From: Tom Errico <thomas.errico@tylin.com>
To: Jean Fraser <JF@portlandmaine.gov>
CC: David Margolis-Pineo <DMP@portlandmaine.gov>, Katherine Earley <KAS@port...>
Date: 7/1/2015 2:45 PM
Subject: 20 Marginal Way - Final Traffic Comments

Hi Jean - I have reviewed the final site plan and find it to be acceptable with the following comments.

Drawing No.
C002

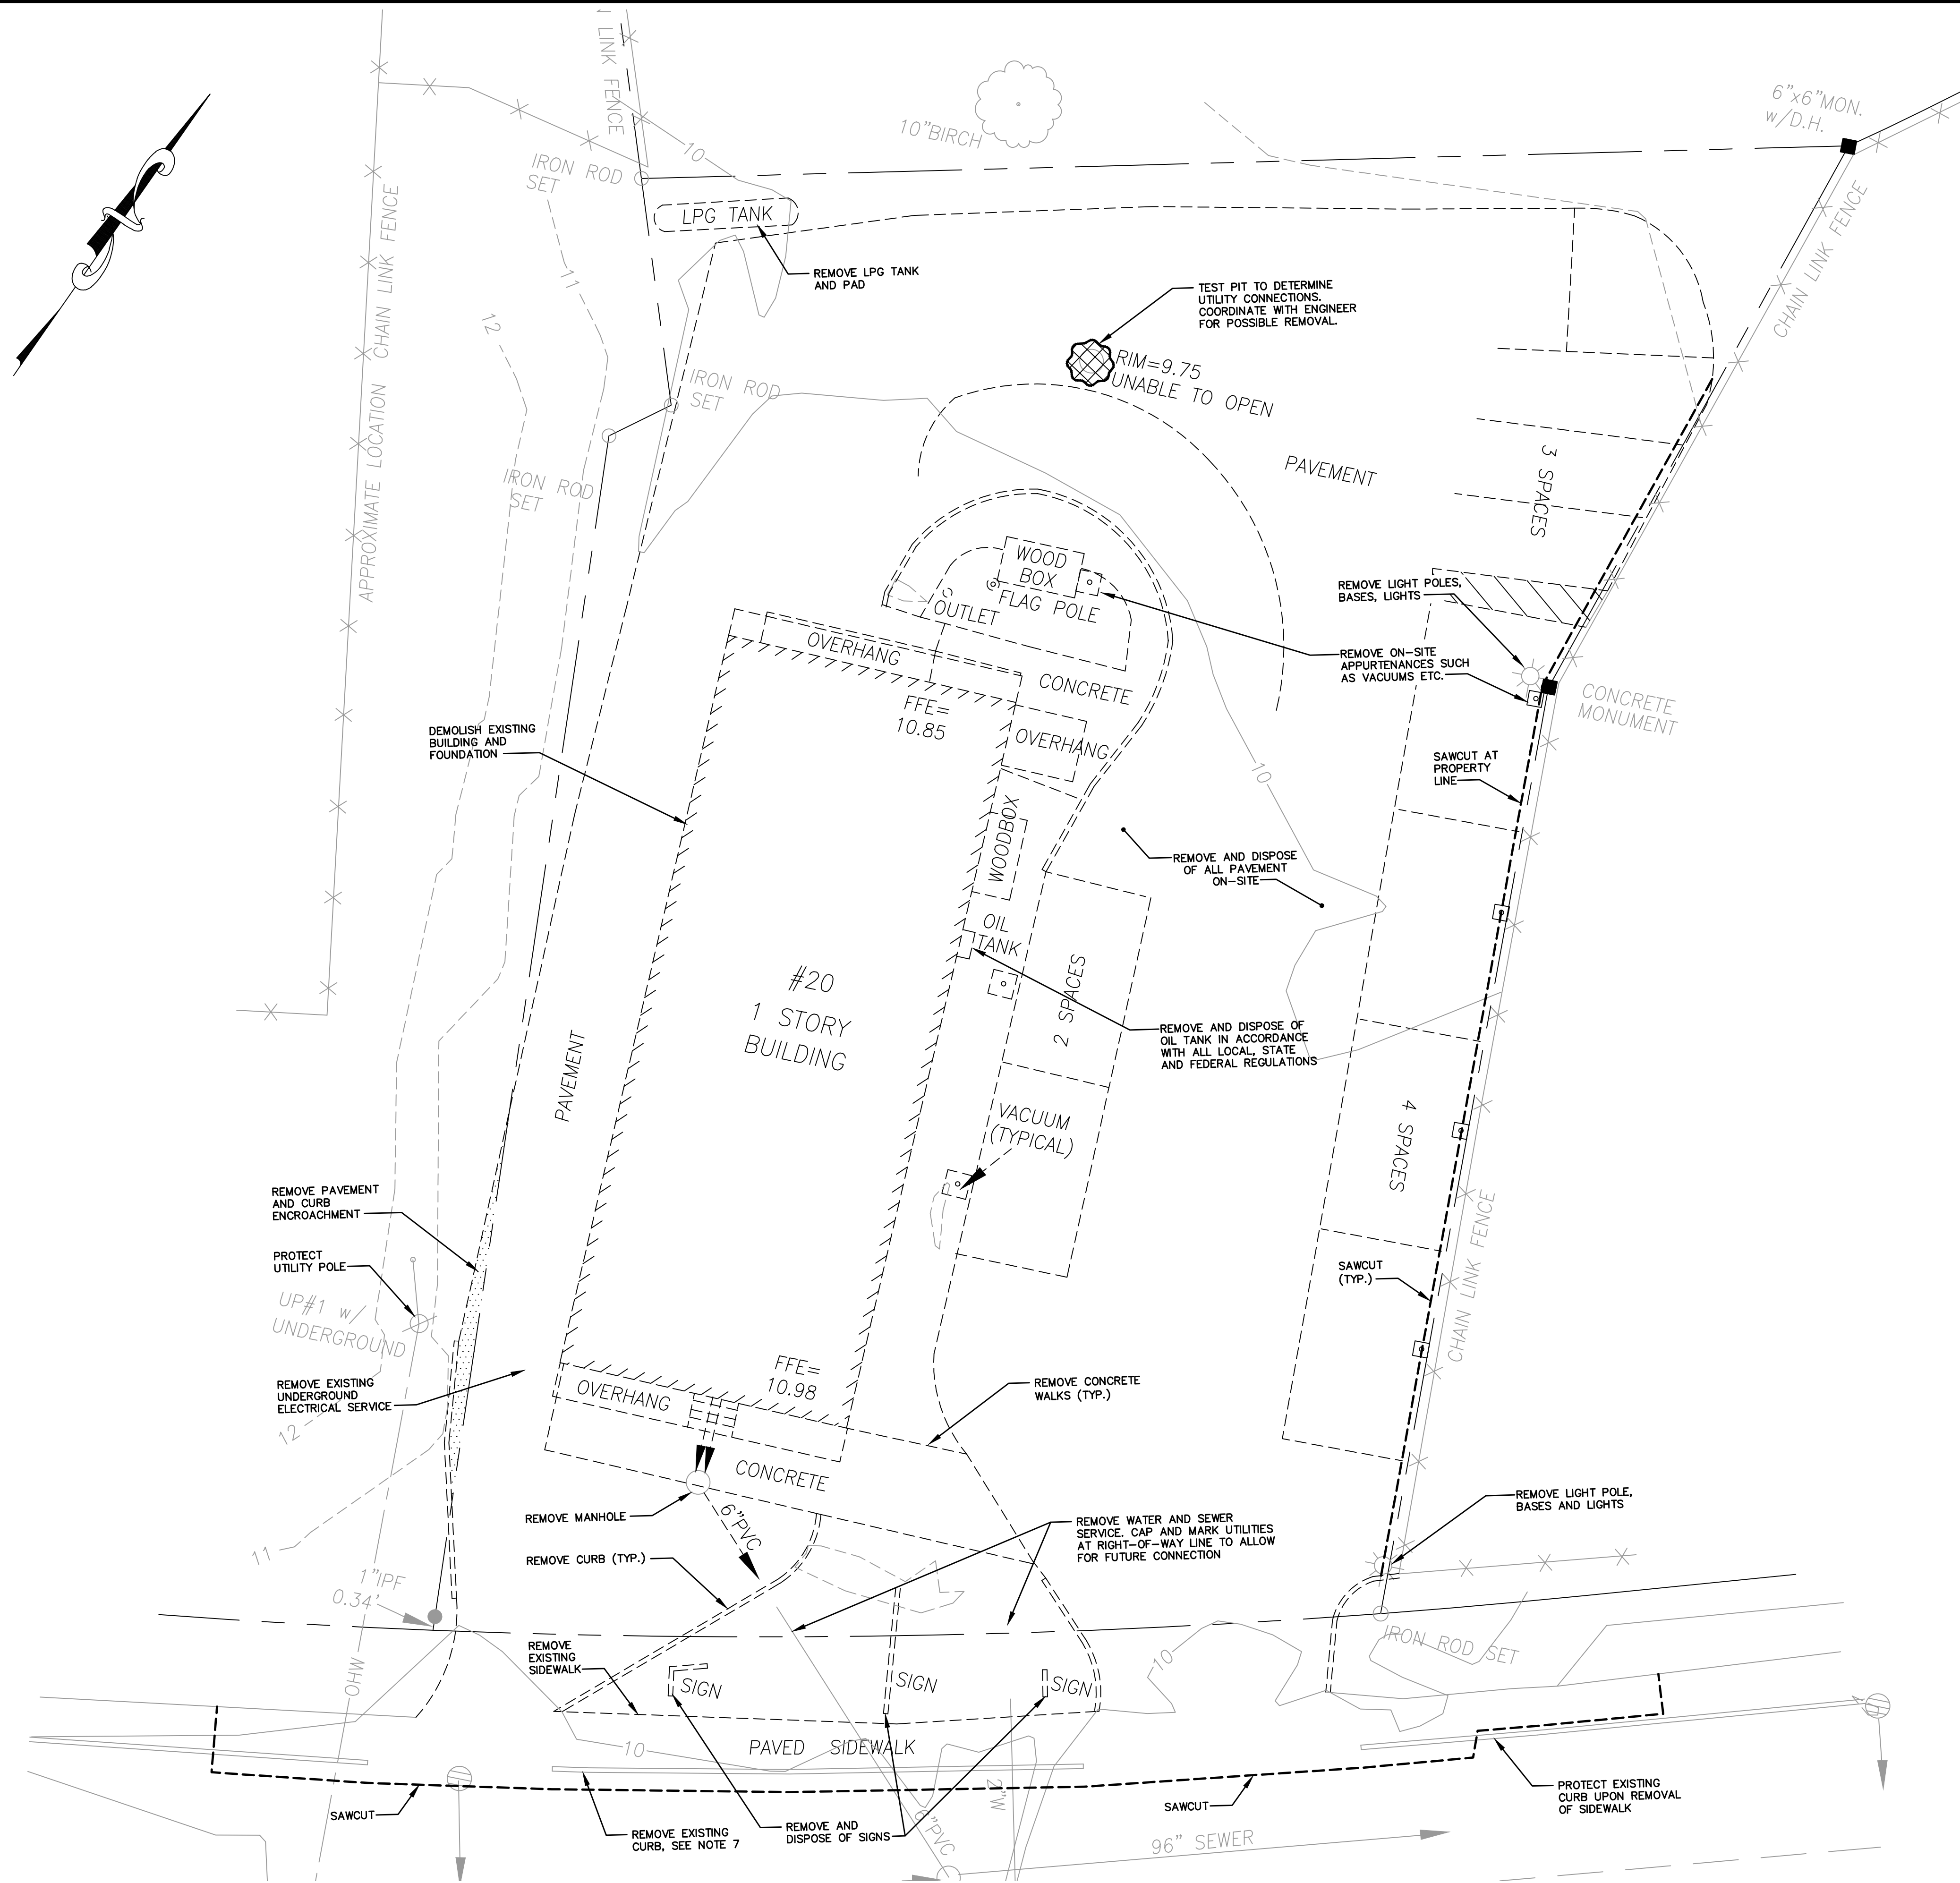
* The proposed driveway does not meet City separation standards with the adjacent Post Office Parking Lot Driveway. I support a waiver from the City's Technical standards as it is preferred that the driveway separation from Forest Avenue be maximized.
